SUZANNE KELLY

20 May 2020

Re: Rye Park Wind Farm – Modification 1 (SSD-6693 Mod 1) Notice of Exhibition

FIGURE 1.1
Locality Plan

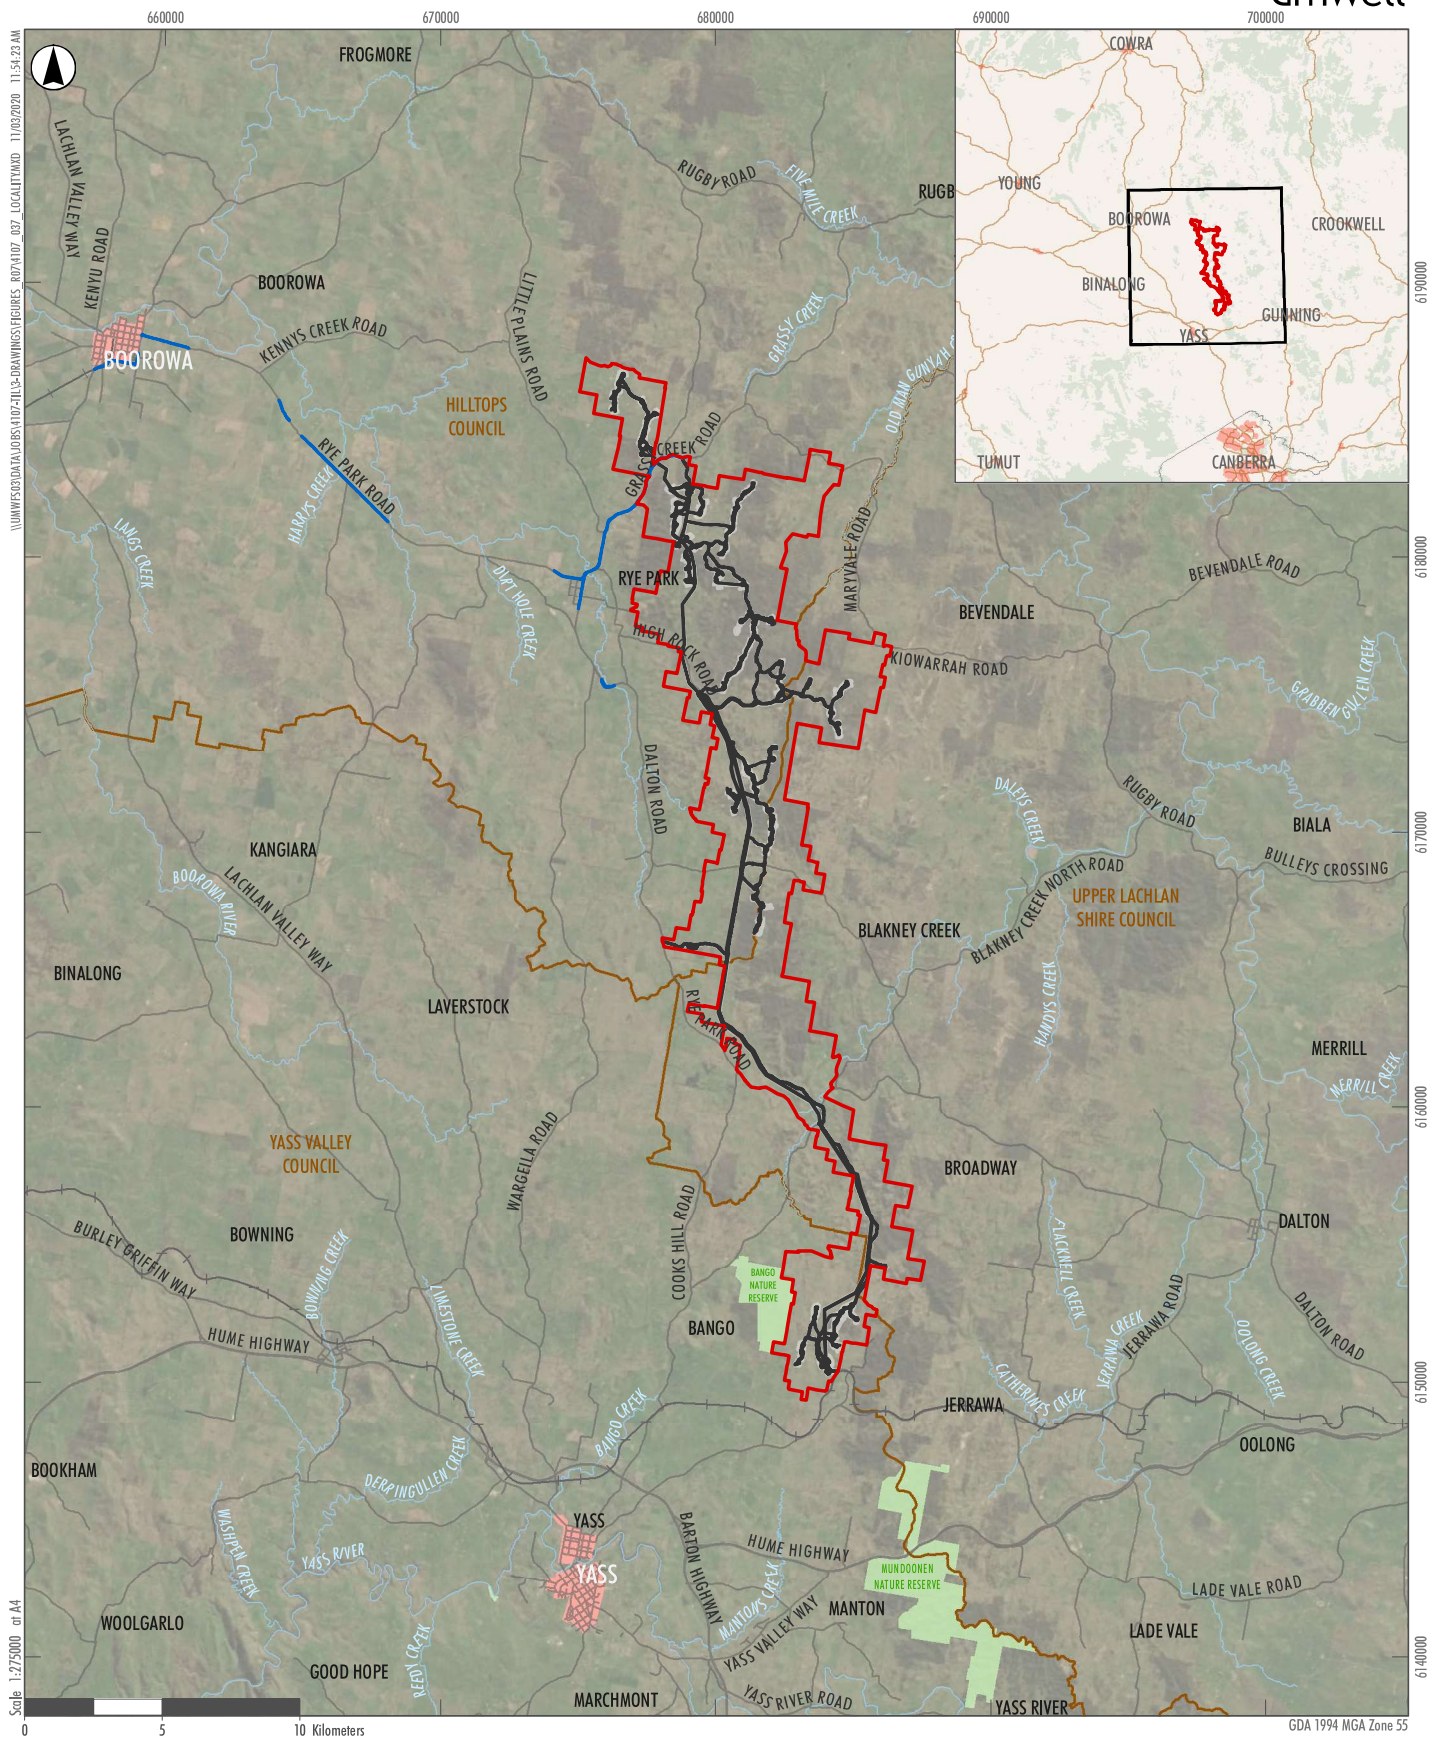
I refer to your letter of the 8th of May 2020 and wish to point out that the application should be declined on the basis that the information submitted is inadequate for a member of the public to properly consider the matter. For example, the main map shows Rye Park in very indistinct letters and there is no other information on the diagram which would allow the reader to judge the whereabouts of the actual wind towers and which residence is which.

In ordinary usage roads like Rye Park Road to Boorowa and the Rugby Road (Rye Park to Rugby) and the Rye Park to Yass Road would be shown on the map to provide some reasonable orientation. Without it I have no ability to make a judgment.

I have said it before that the maps that are provided are inadequate.

Evidence of the inadequacy of the maps is indicated by the following quote from your letter: "...application to modify the consent for the Rye Park Wind Farm, located at approximately 4 kilometres West of Rye Park and 15 kilometres North-West of Yass."

Rye Park is in such small printing on the map that it is hard to locate but it appears to be on the Eastern edge of the overall plan for wind farms and not 4 kilometres to the West. Most wind farms are located to the East.

The increase in tip height from 157 metres to 200 metres means that visibility is all important and to judge the visibility of the wind farm and the closeness for noise requires being able to locate each tower with reference to a known locality.

Under the circumstances I object to the modification and request that consideration of it be deferred until useful maps are prepared.
